**Re: Lot 1 Block 2 Unit 18 Volcano Cliffs, S.A.D. 228
6616 Petirrojo NW
Request Permanent C.O. – Accepted
Engineer's Stamp dated: 2-19-18 (D10D003G1)
Certification dated: 10/26/18**

**Re: Lot 1 Block 2 Unit 18 Volcano Cliffs, S.A.D. 228
6616 Petirrojo NW
Request for Permanent C.O. – Not Accepted
Engineer's Stamp dated: 2-19-18 (D10D003G1)
Certification dated: 10/23/18**

CITY OF ALBUQUERQUE, BERNALILLO COUNTY		NEW MEXICO	
LOT 1, BLOCK 2, UNIT 18 VOLCANO CLIFFS SUBDIVISION			
SOUMPHOLPHAKDY - 6616 PETIRROJO - GRADING & DRAINAGE PLAN			
McDowell Engineering, Inc.			
7820 BEVERLY HILLS AVE. NE • ALBUQUERQUE, NM 87122			
TELE: 505-828-2430 • FAX: 505-821-4857			
Designed JSM	Drawn STAFF	Checked JSM	Sheet of
File SOU0118L	Date FEBRUARY, 2018		1 1

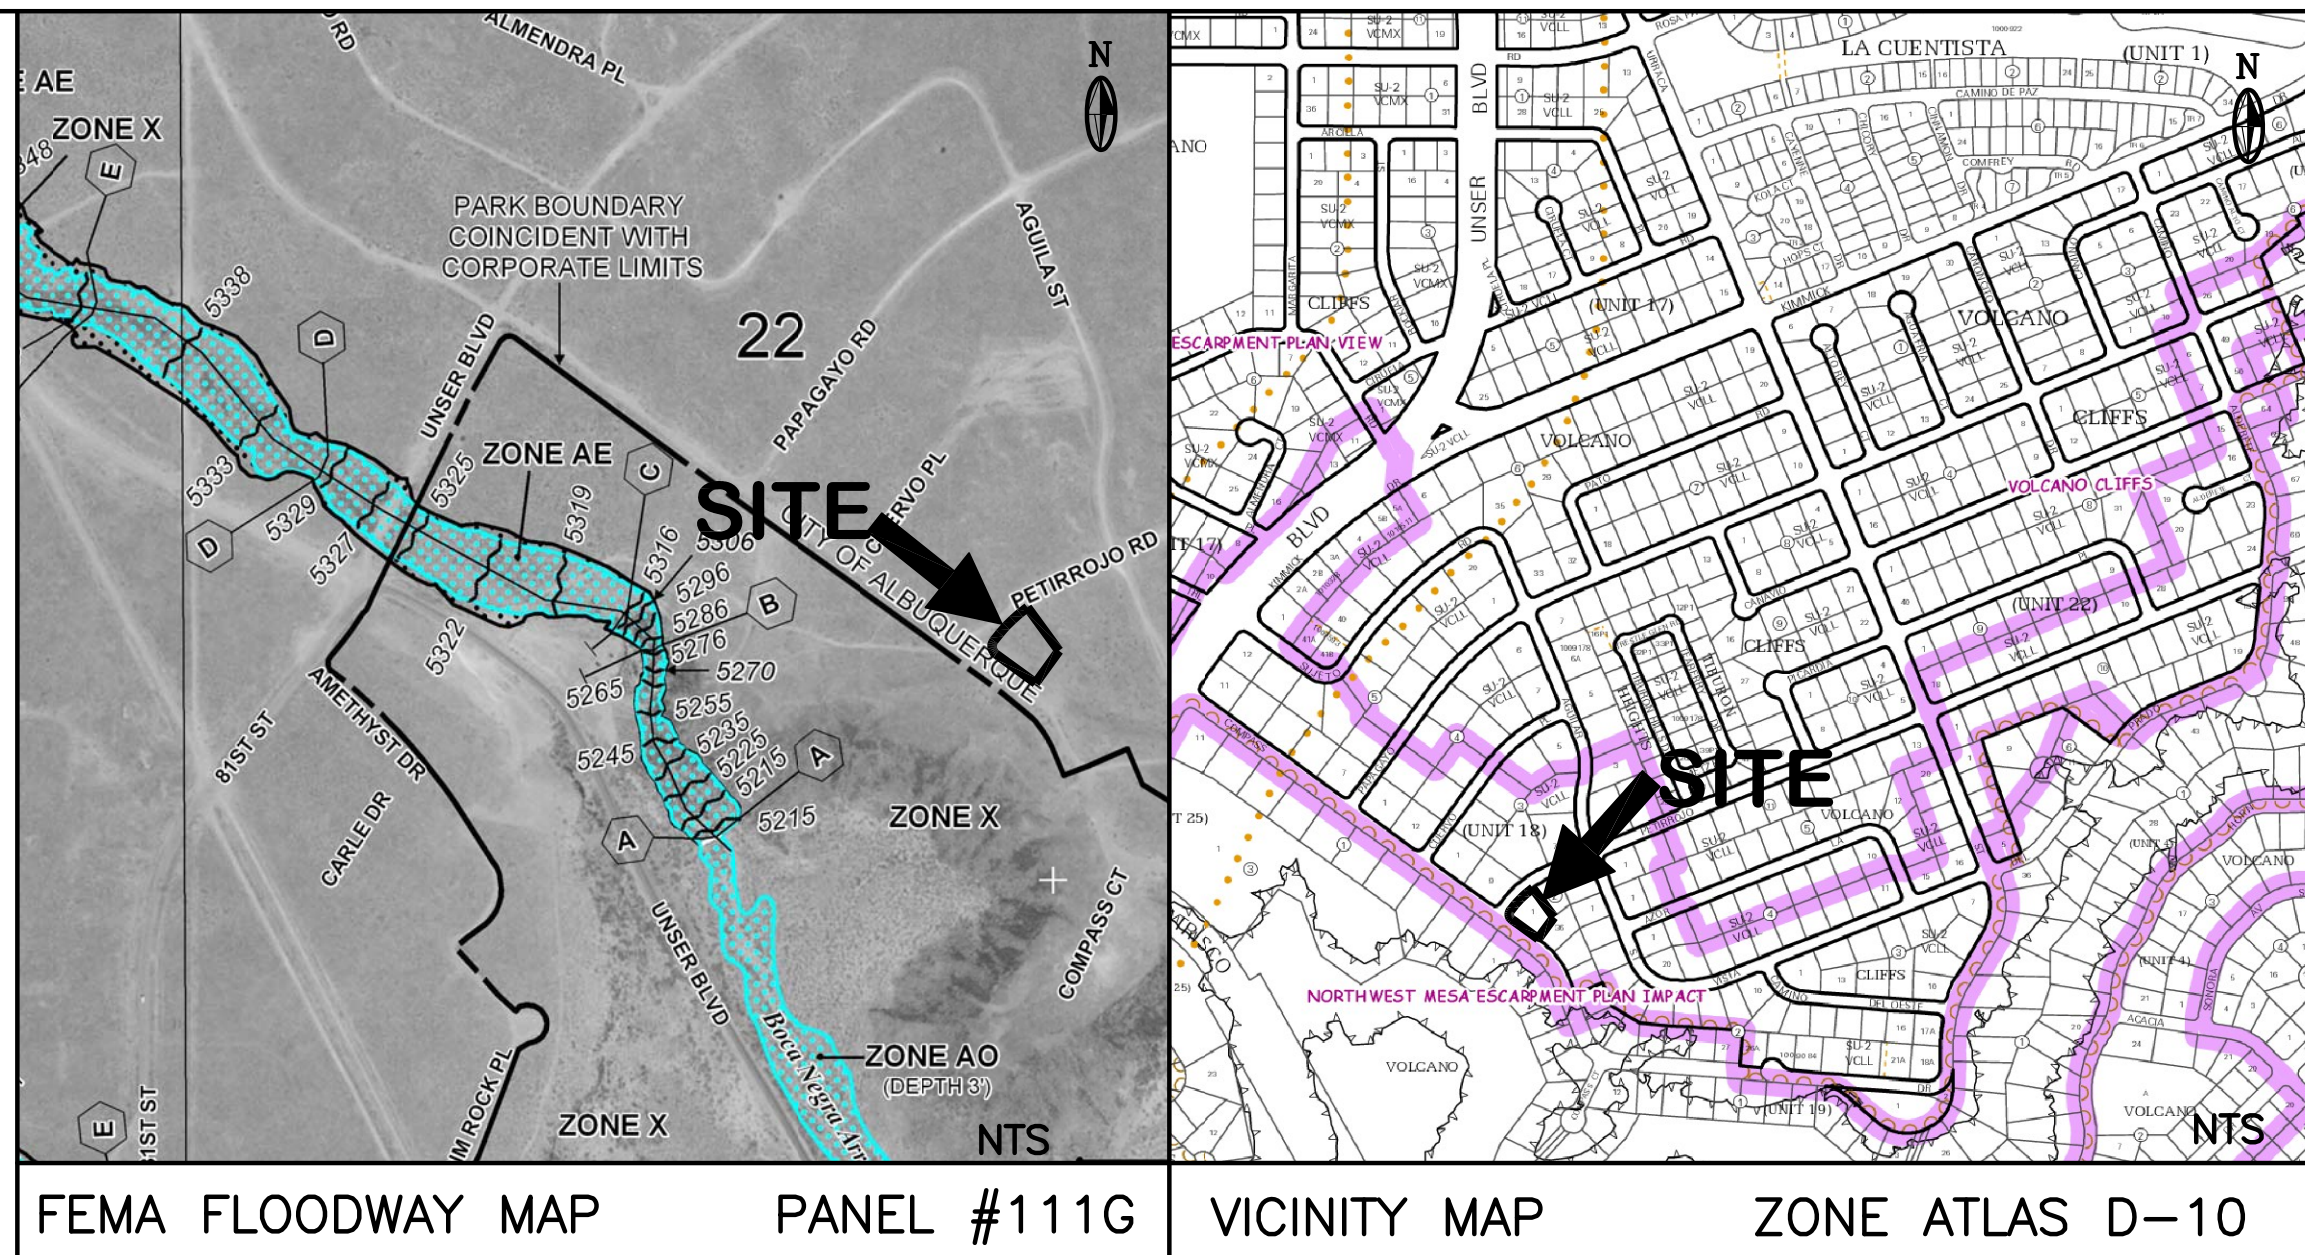
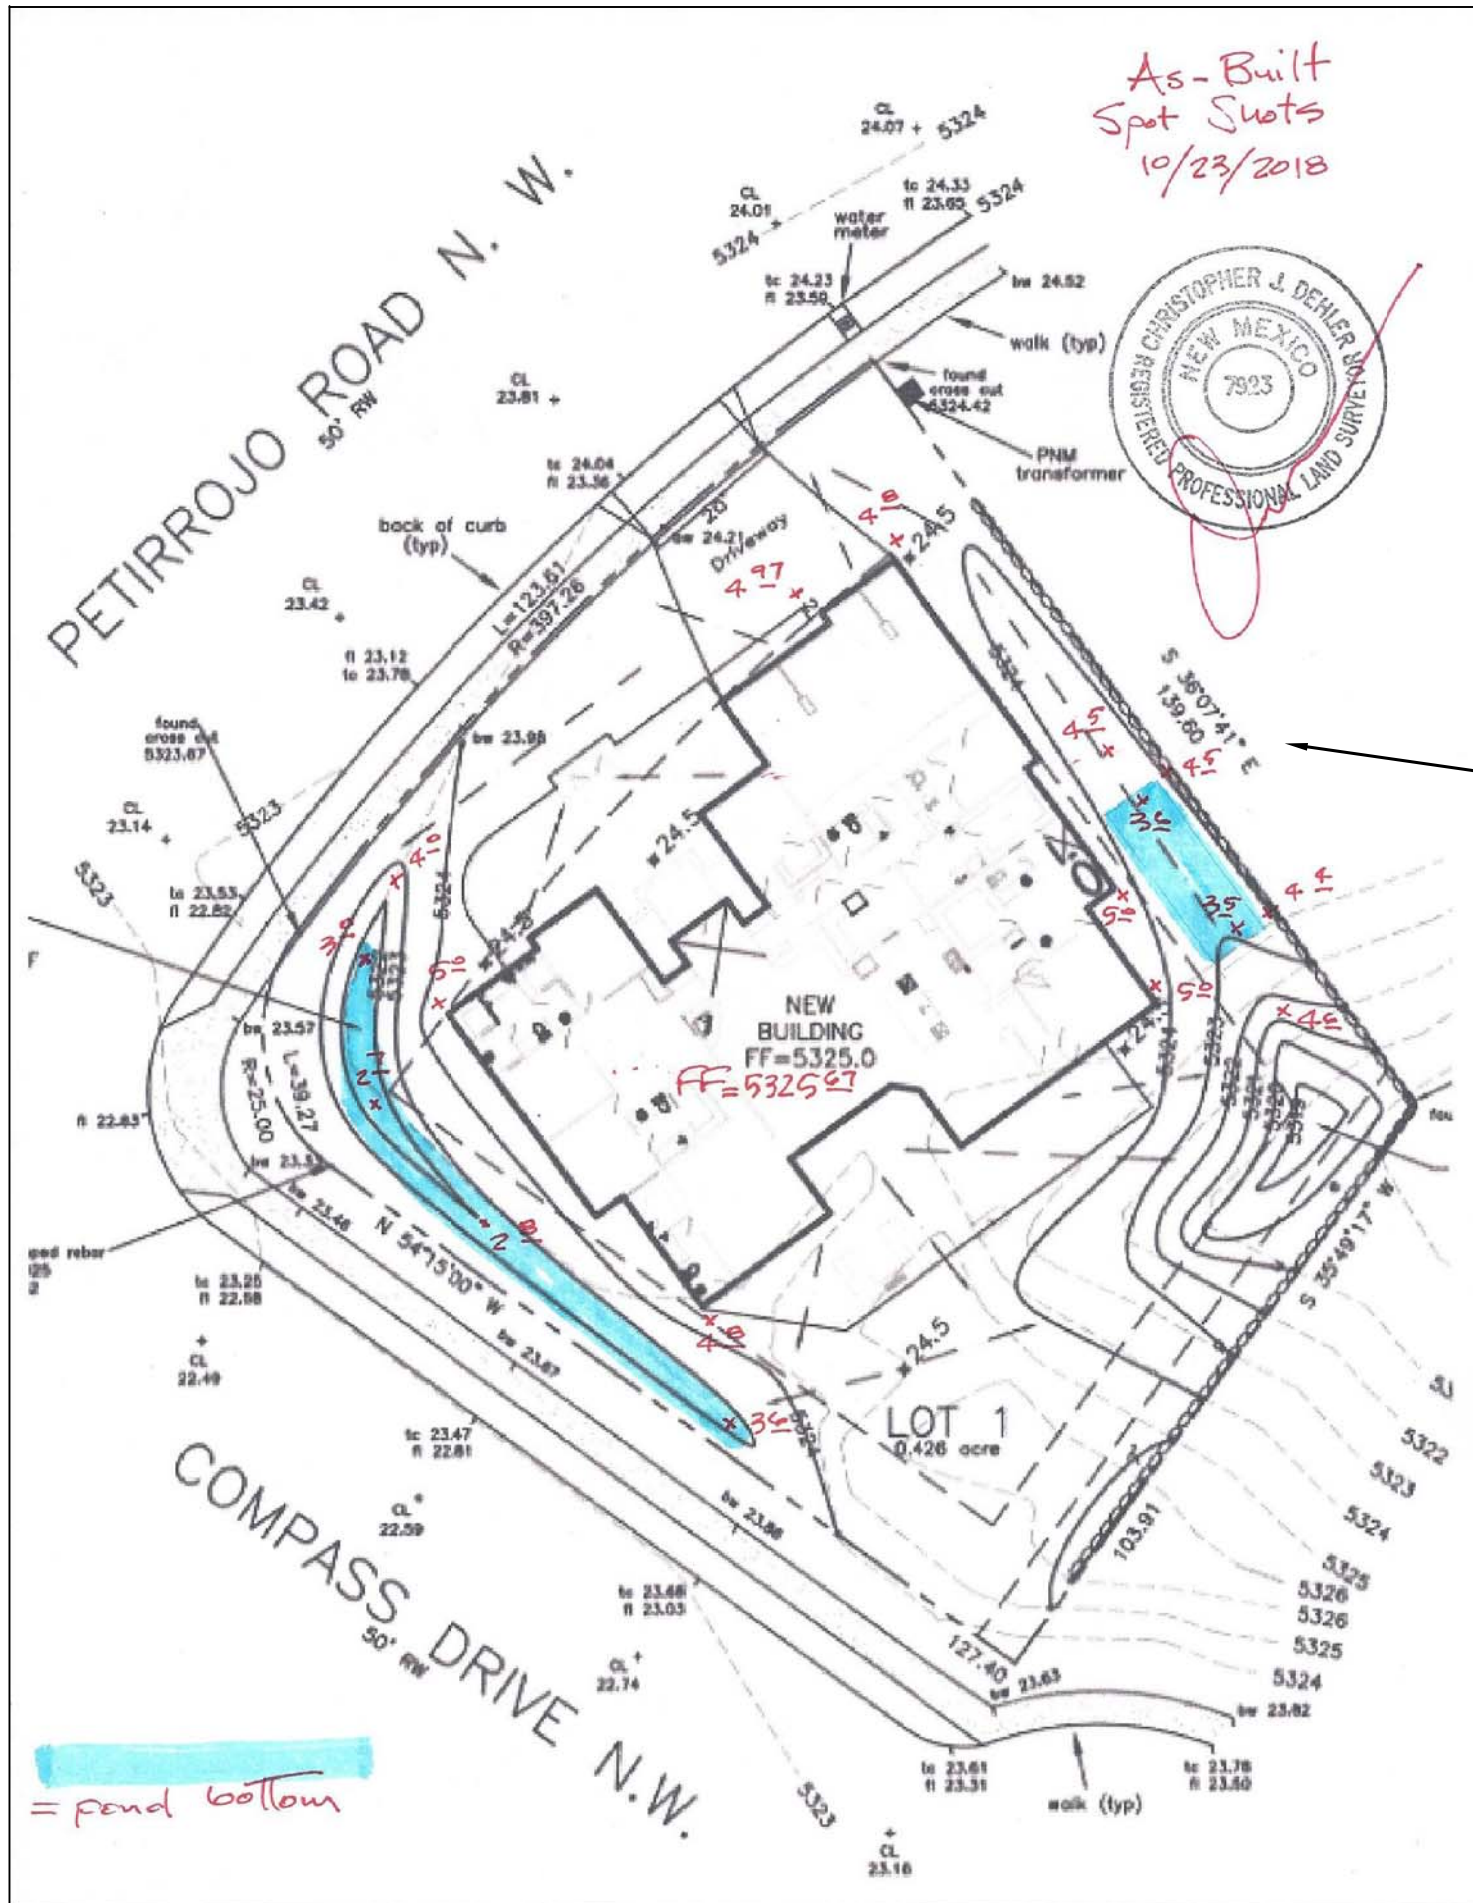
- Remove dirt from used as a ramp in street and sidewalk. **Done.**
- Provide how the raised lot will be protected from erosion on the North and west sides of the property line. **Landscaping will be provided at these locations to prevent erosion**
- Prevent the flows from entering Compass Dr. at the S.E. corner of the lot. All flows must enter the retention pond before flowing out into the public right of way. **Berm installed**
- Remove the debris pile and the container from the lot to the north.
Debris has been removed and container will be removed after the CO is issued.

All these items have been discussed with the owner and grading contractor, Will, and Rudy Rael and all items have been satisfied via email distributions.
